Please ask for: Jonny Cooper
Email: jonny.cooper@arun.gov.uk
Telephone: 01903 737532
Our Ref: R/196/24/CLP
Your Ref:
Date: 11th October 2024

Lawful Development Certificate for a Proposed Use or Development

Development: Lawful development certificate for the proposed use of land to station a mobile home granny annexe for use incidental to the main dwelling.
Location: 21 Mill Lane Rustington BN16 3ED

Drawn by : MISCHA
	Client : MR & MRS HUBBARD
	Drawing Title : PL LOCATION PLAN
	Scale : 1:1250 @ A3
	Date : 30 September 2024 14:34:11
	Drawing Reference : 3500.24 - HTB- PLLP - OPT2B
	Revision Number : -

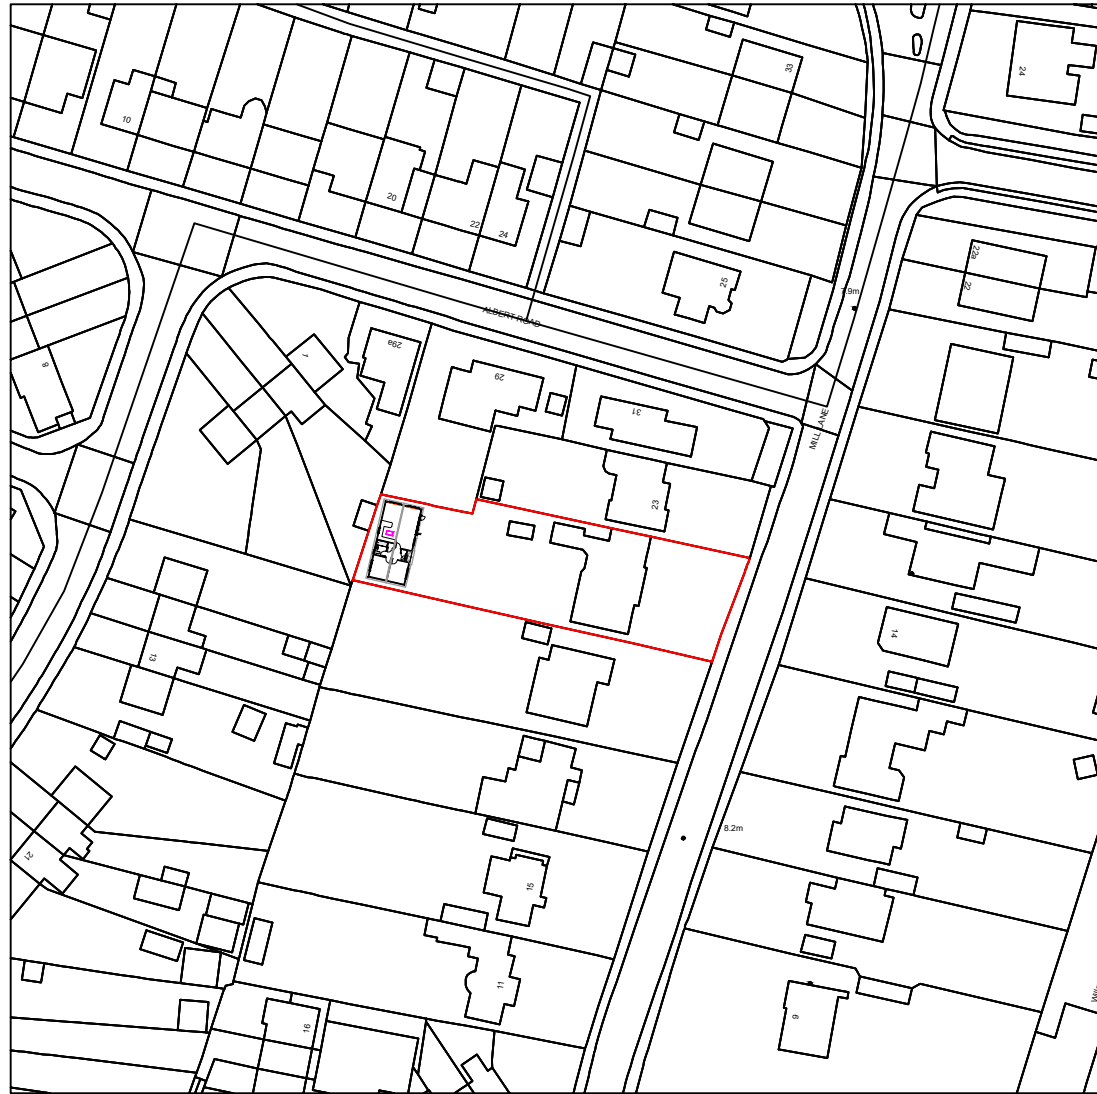
Please amend your block plan to include distances from the proposed annexe to the site boundaries.
